From: Amanda Scholes on behalf of Planning.Responses
Sent: 24 November 2020 09:45
To: Planning Scanning
Subject: FW: *EXTERNAL: FW: A/157/20/DOC - Land South of Water Lane, Angmering.

Please upload onto Ocella the email trail from the applicant regarding the **Construction Management Plan** for the discharge of condition application **A/157/20/DOC** relating to Land South of Water Lane, Angmering.

Appendix C – Routing Plan

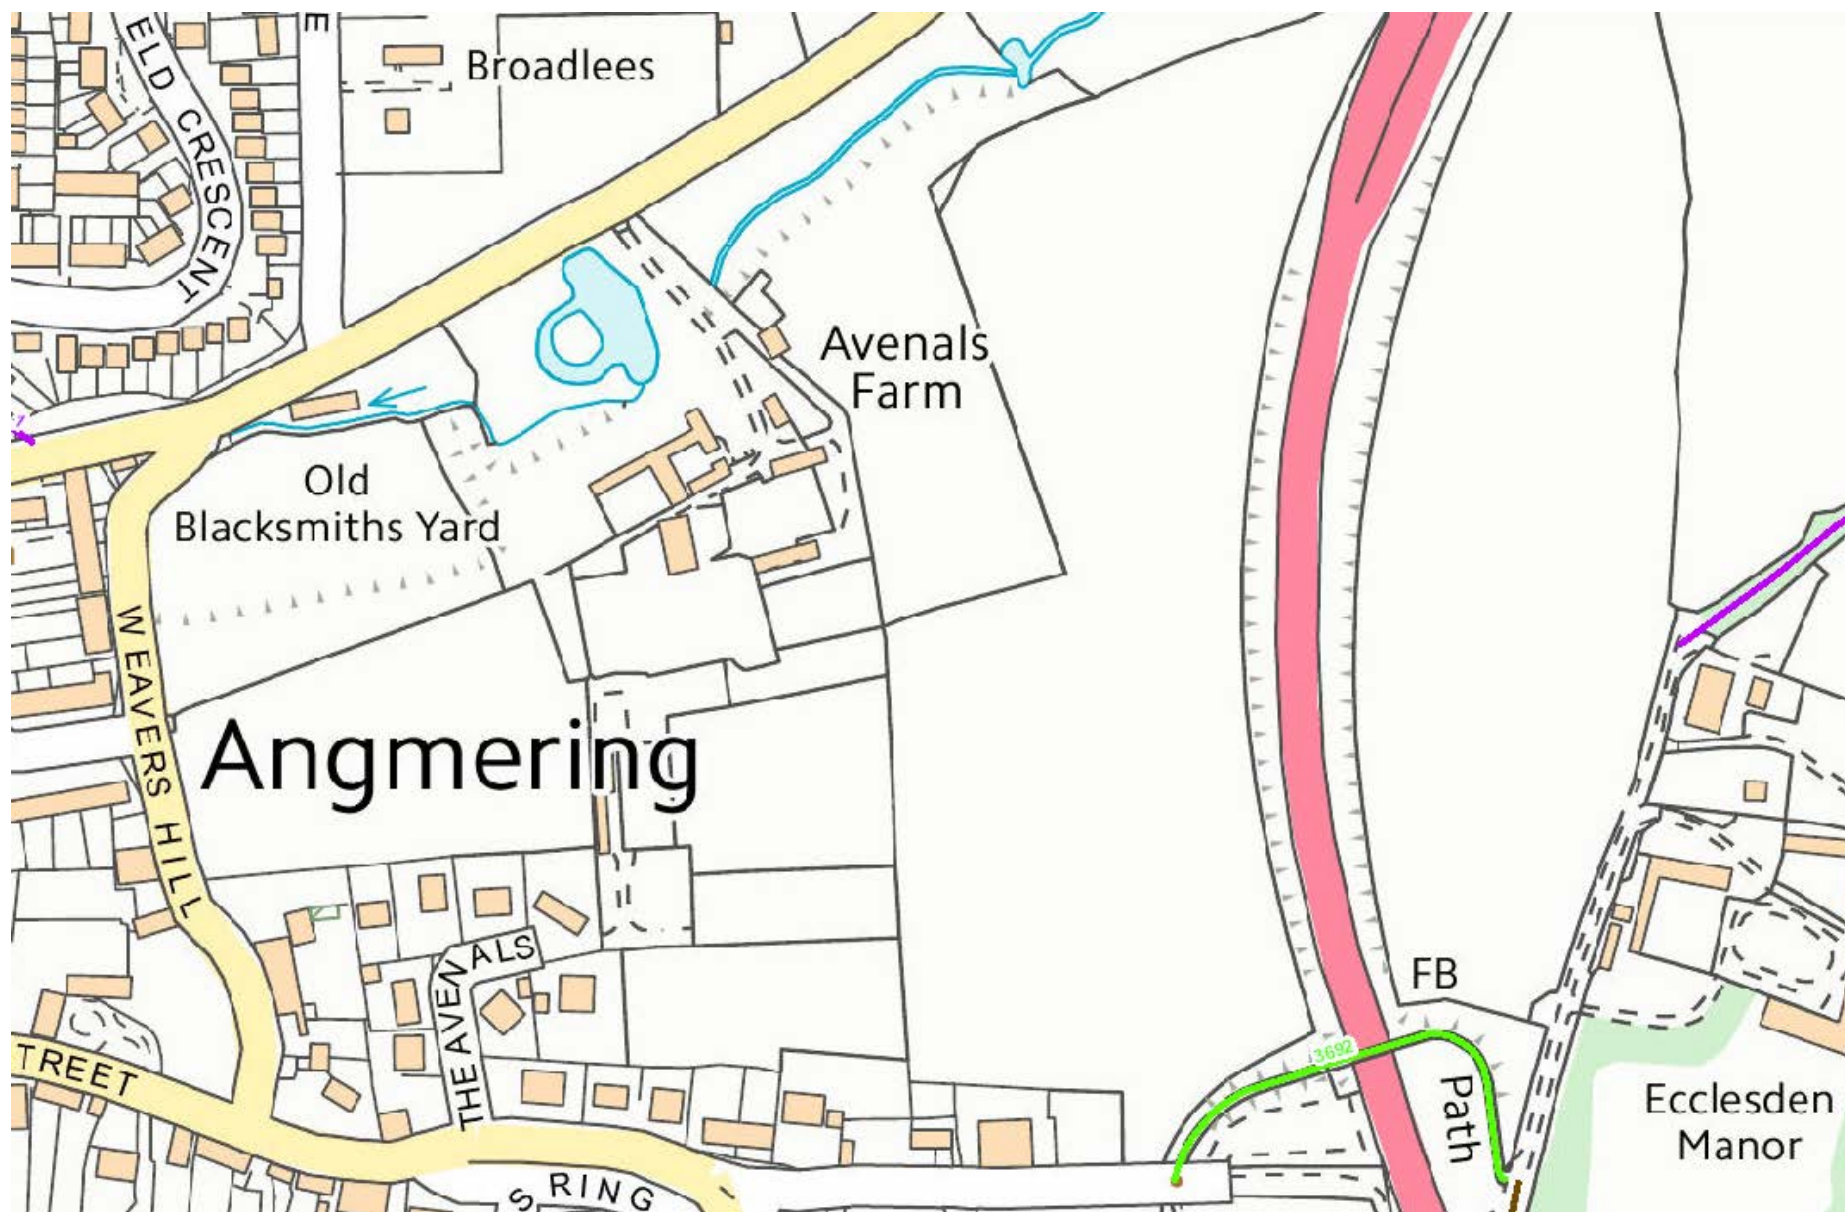
The above document revises the access road to initial site works, which will now be via Roundstone Lane and as first proposed, the High Street, Angmering. Although it continues to note no likely impact on the Highway Network, it fails to address the impact on residential units in the immediate vicinity of Roundstone Lane and the High Street.

Houses at the northern section of Roundstone Lane (at the High Street) and on the High Street, are close to these roads and likely to be detrimentally impacted by site traffic noise/vibration, most particularly from HGV's. These will pass close by, over potentially prolonged periods of time each weekday and over the 7 months to September 2021. The situation is exacerbated since this now restricted time frame is likely to mean that more HGVs will use this access per day/hour than previously described. This number of vehicles and their impact should be stated.

In conclusion, residential units at the top of Roundstone Lane and in particular the High Street, are likely to be detrimentally impacted by noise should this be the accepted access route. I would advise that The Construction Management Plan should allow for the provision of a temporary (or permanent) bridge allowing access to the site from Water Lane from the outset.

To follow on, the edits are contained within Paras. 2.1 – 2.7, with an amendment to the routing plan (Appendix C)
